Your Ref: OWPC20095
Our Ref: LU/247/18/HH 22-08-2018
Please ask for:
Zac Denton

Demolition of single storey lean-to & erection of single storey rear extension. This application affects the character & appearance of the Littlehampton Seafront Conservation Area & may affect the setting of a Listed Building
13 Norfolk Road Littlehampton

Thank you for your internet representation made on 6th October 2018 which has been recorded as '**an objection**' with the comments as follows:

SOUTH ELEVATION Drg no 2018/MEL/04 Aug 2018 Scale 1:50@A3

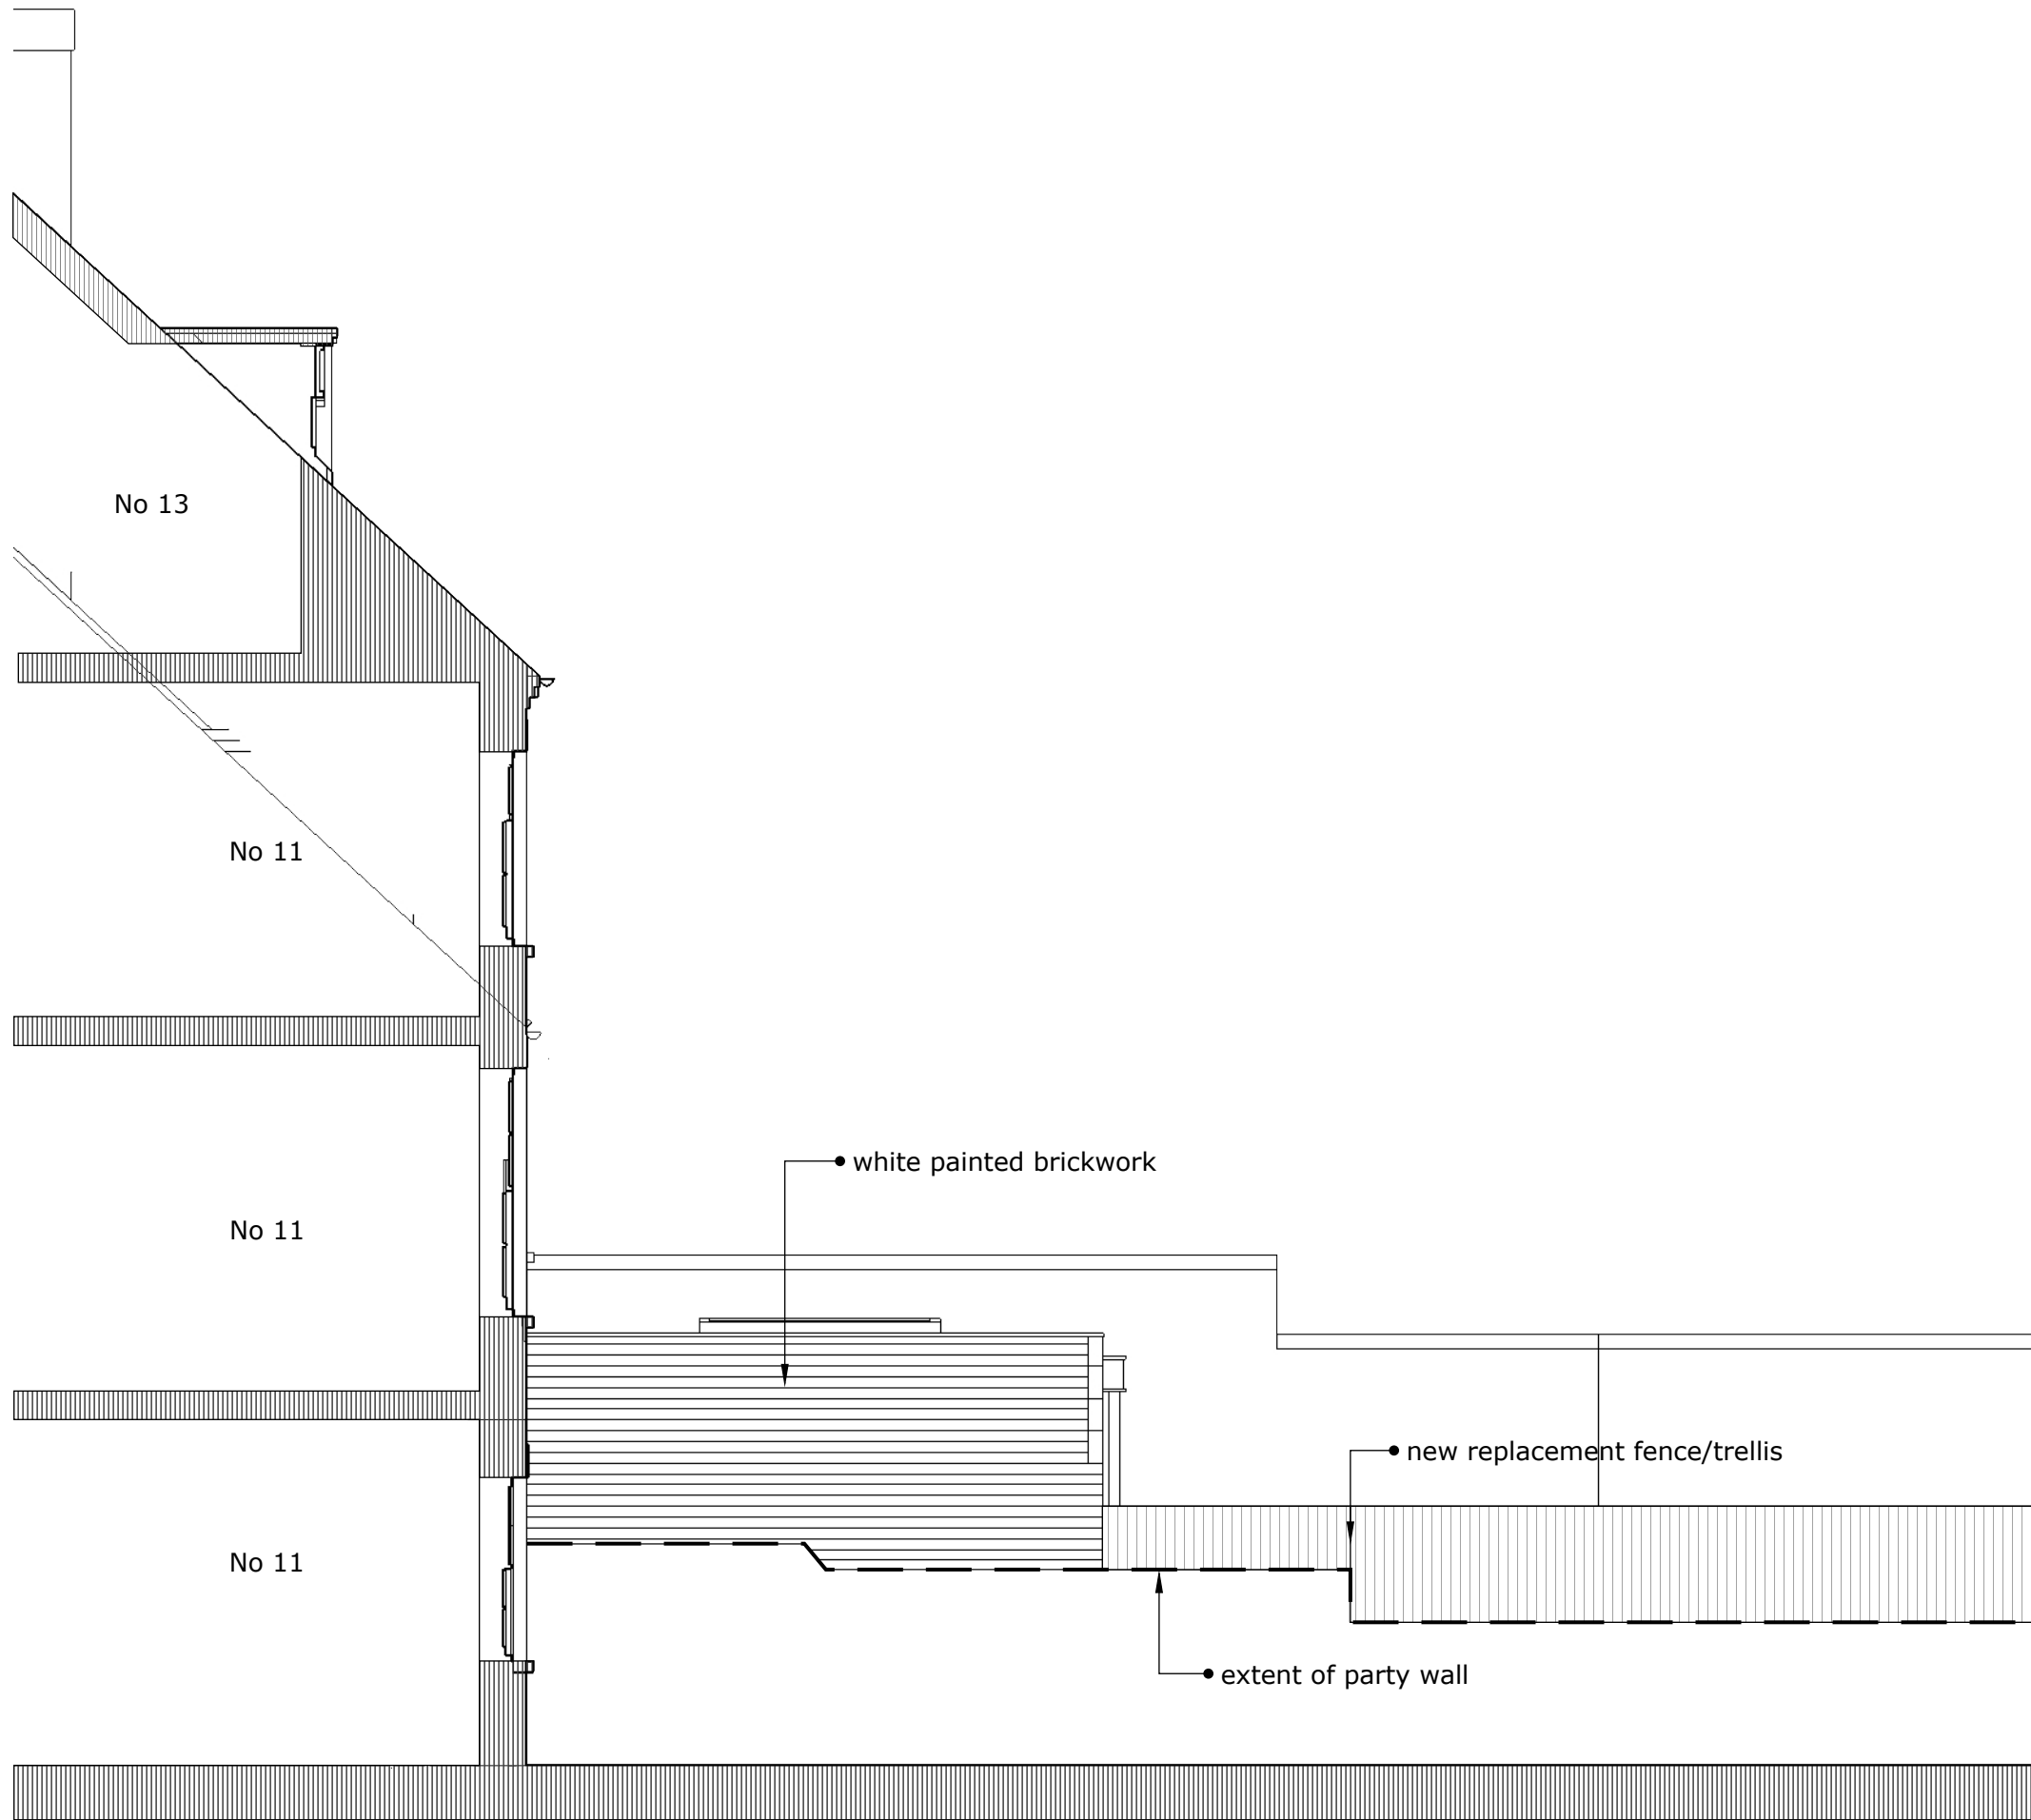
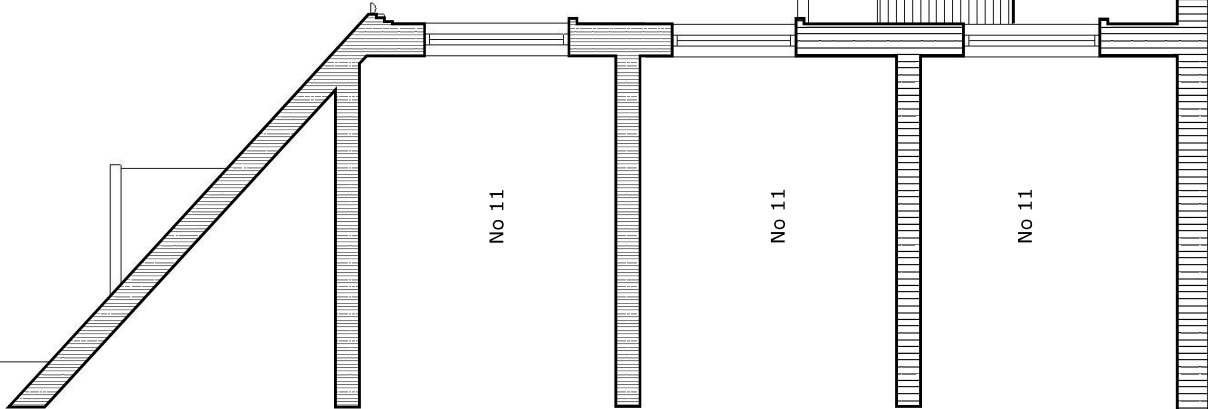
- 1/Loss of natural light into the living room/dining room and kitchen. Note; original wall and fence is 2 metres high, proposed new wall is 3 metres high.*

- 4/NO Proper access for building work to be carried out.*
- Our main objection is to the height of the extension as it will totally change our living environment and we will lose sight of the sky from the rooms mentioned.*

PROPOSED GROUND FLOOR PLAN Scale 1:50

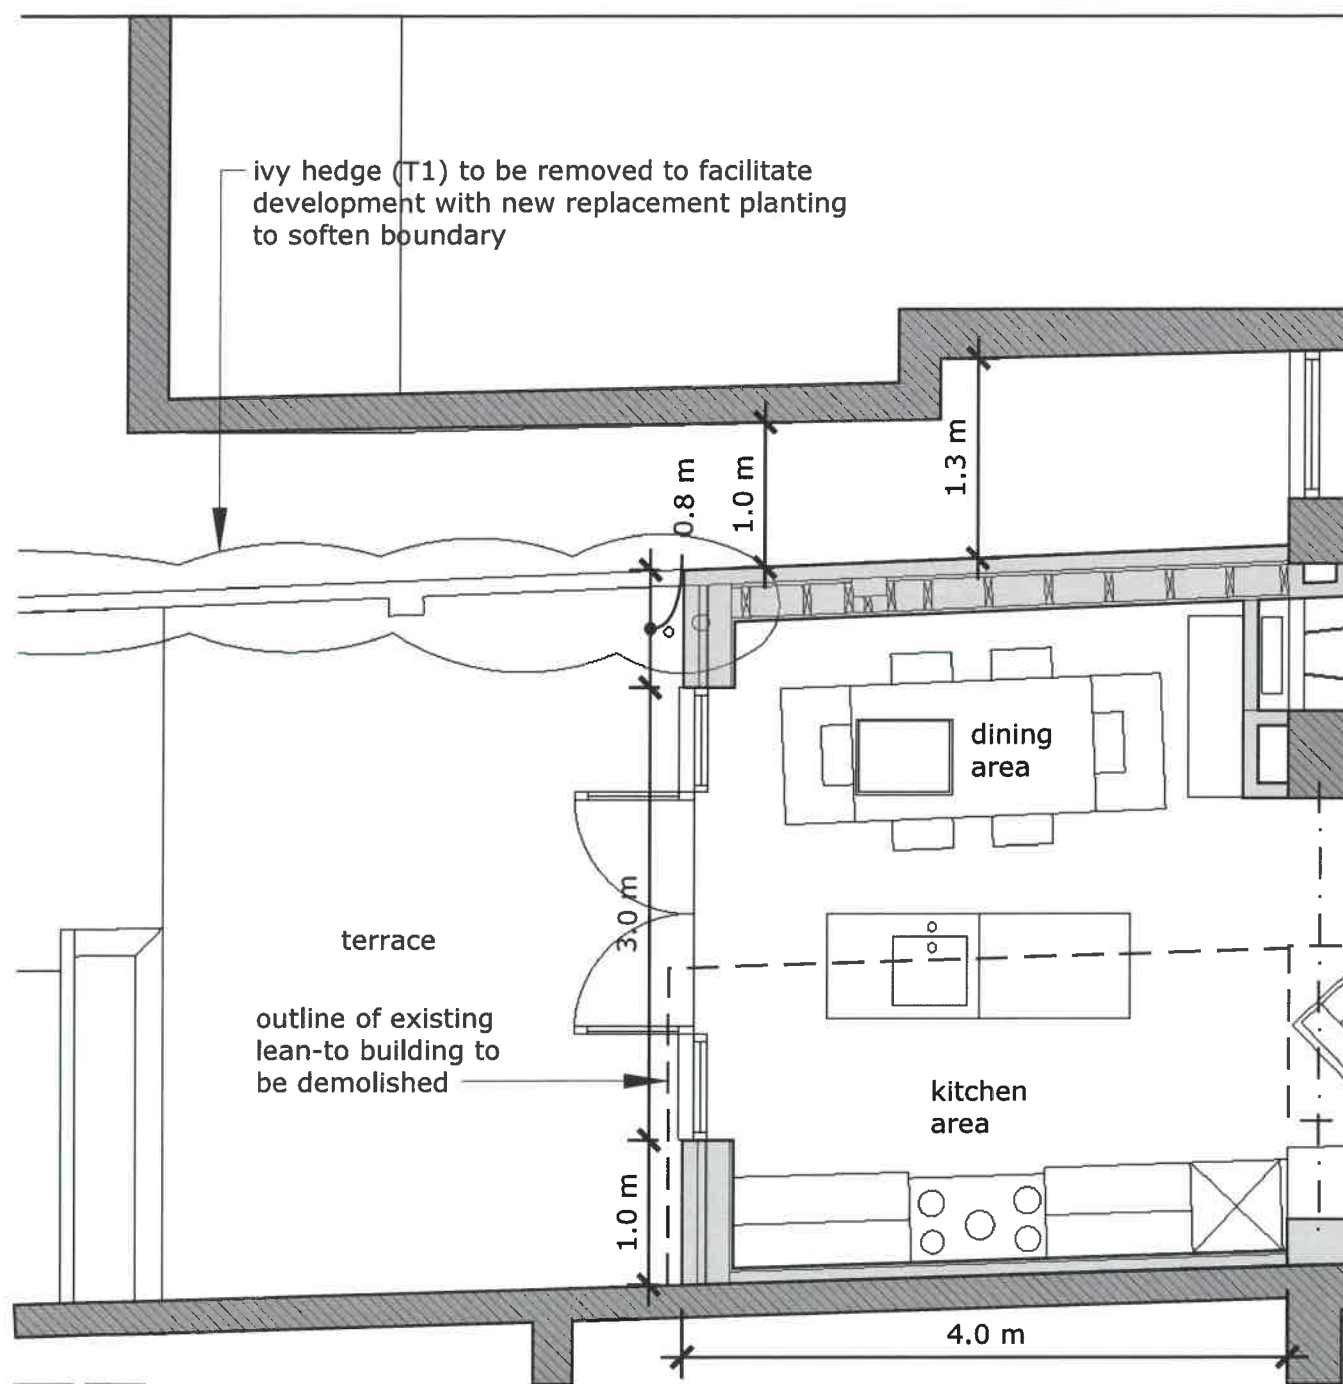
- The loss of light will also affect the kitchen area.*
- 3/The distance between our building and the original wall is at one point as shown on plan only 1.00 metre and at the next point 1.4 metres although the proposed plan shows 1.3 metres.*
